**Consultation Response from Alan Smith,
KC Waste Strategy (Refuse & Recycling)**

2024/92031 Headlands Works, Headlands Road, Liversedge, WF15 7NT

Outline application for erection of residential development, adoptable road and public open space

Responding Ref: WPN 25 028

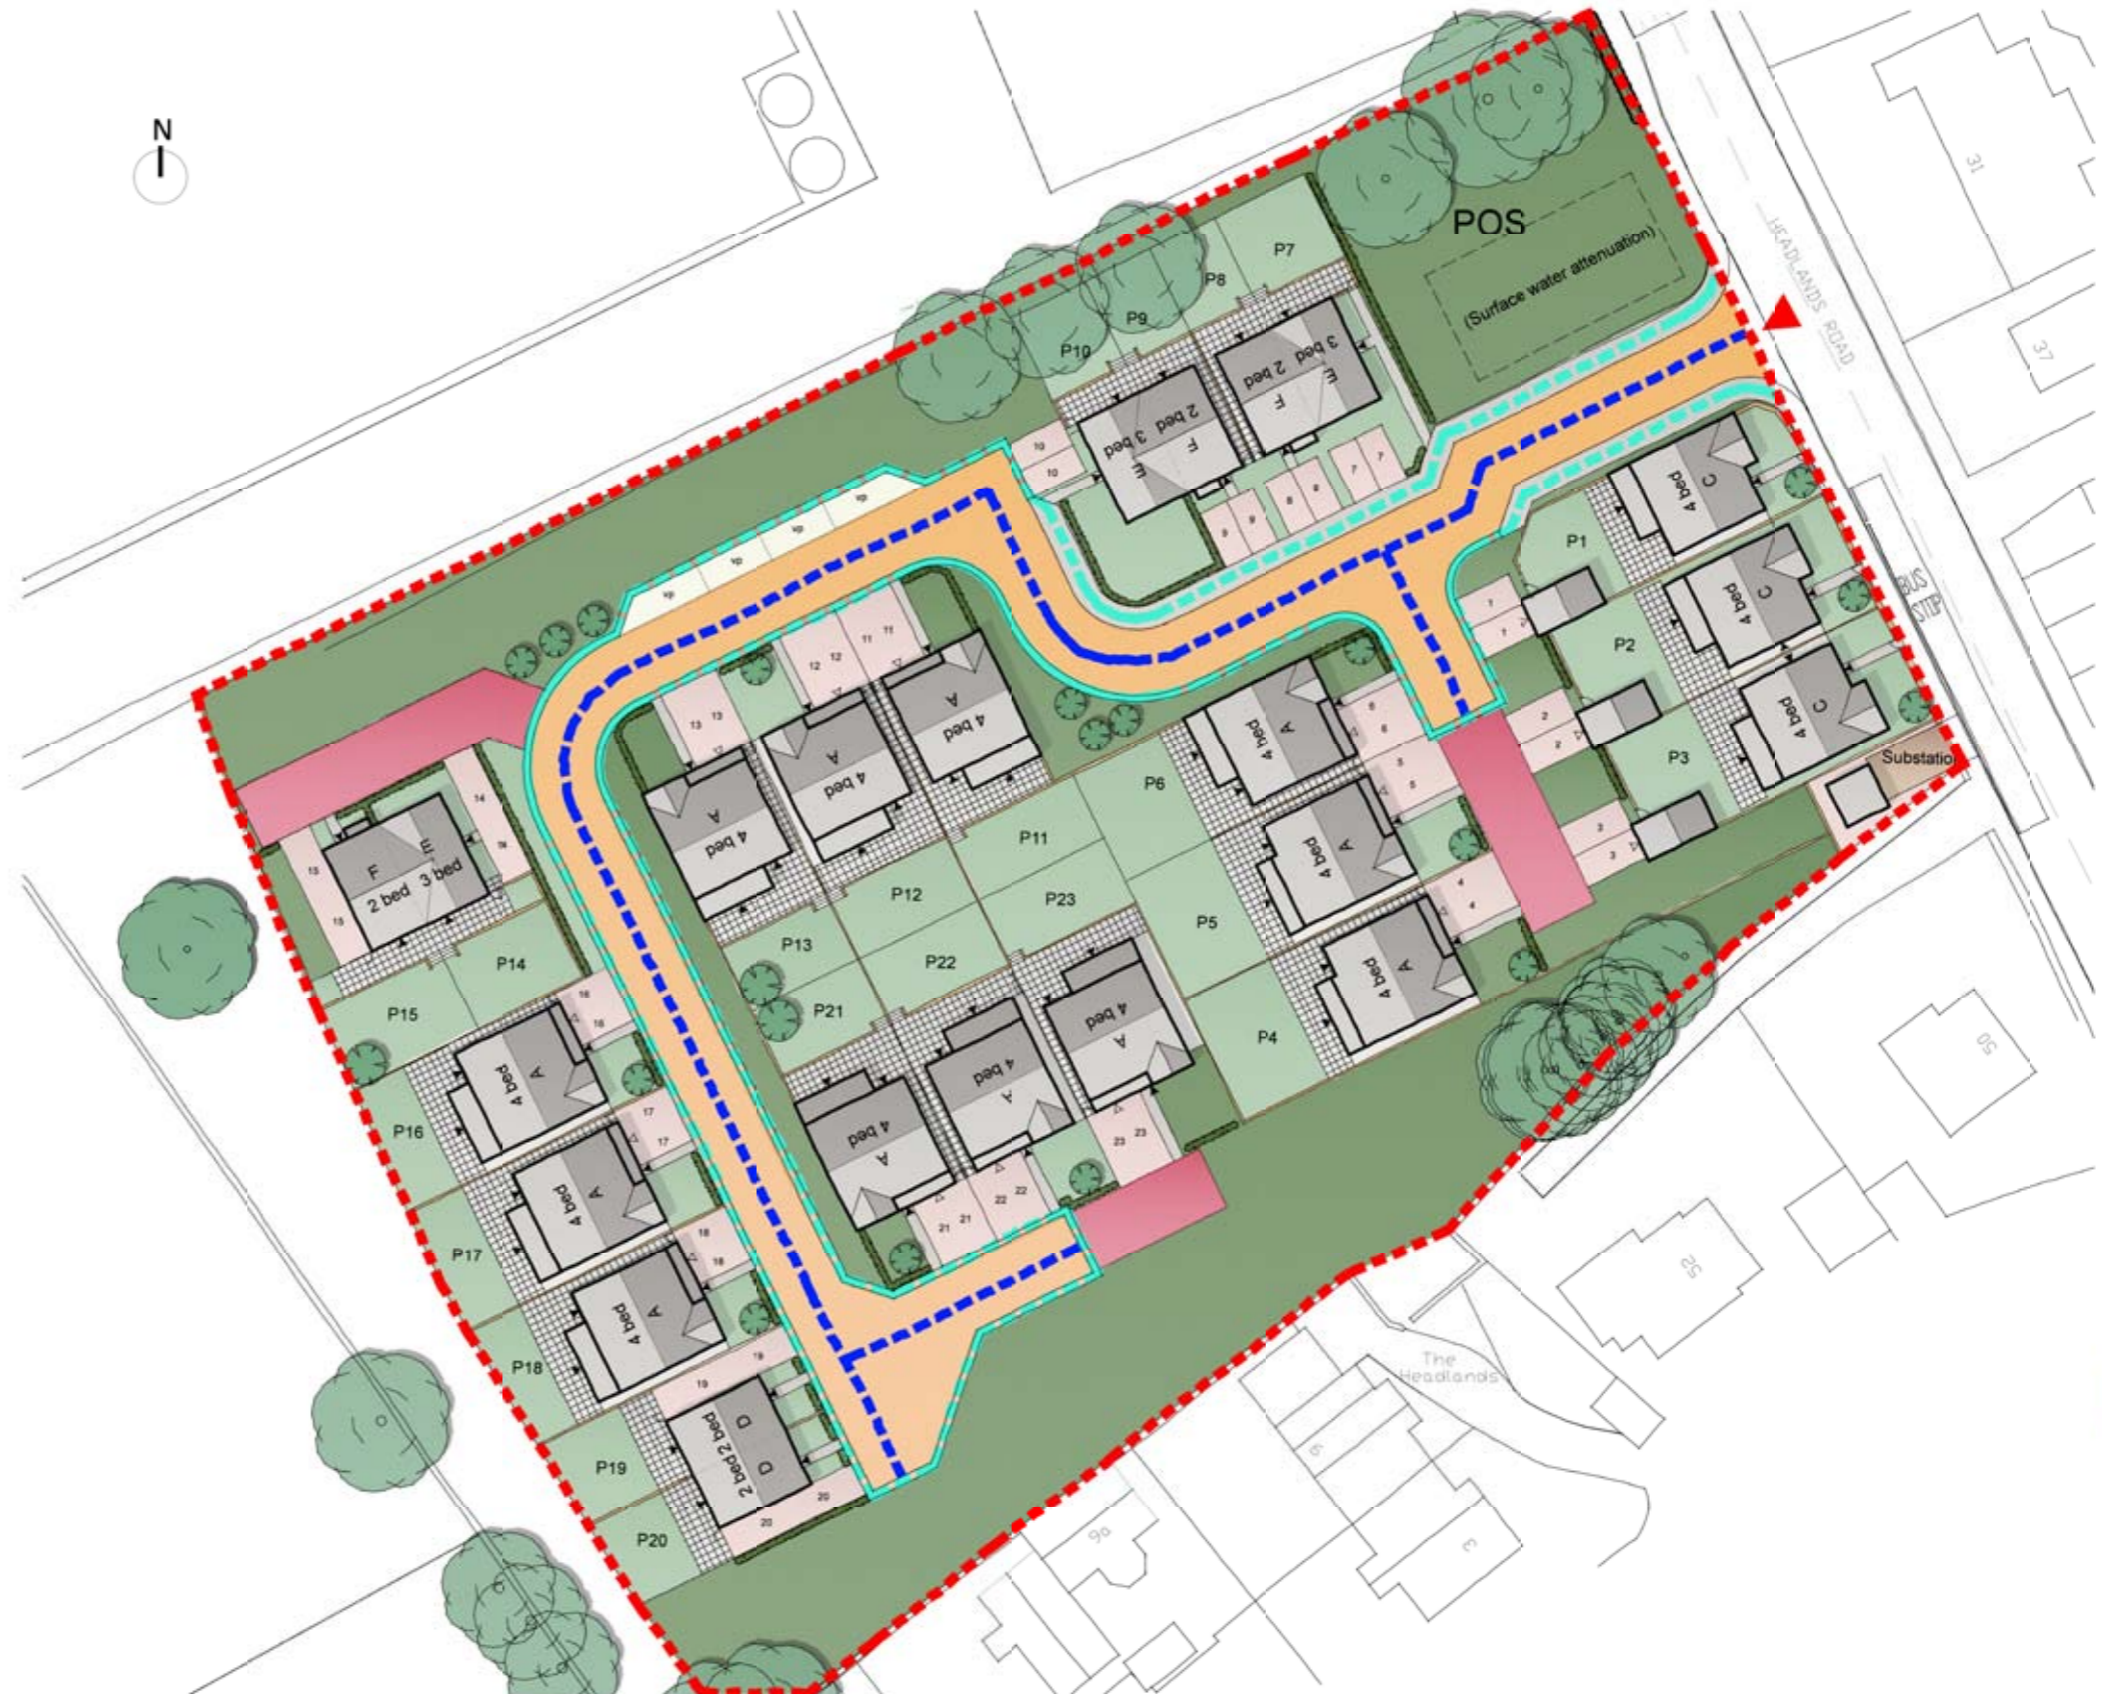
- Site specific comment
 - Plots 27 to 29 will need a BCP adjacent to the adoptable highway outside plot 27. The area must be on hard standing and large enough to hold 3 x 240L bins.
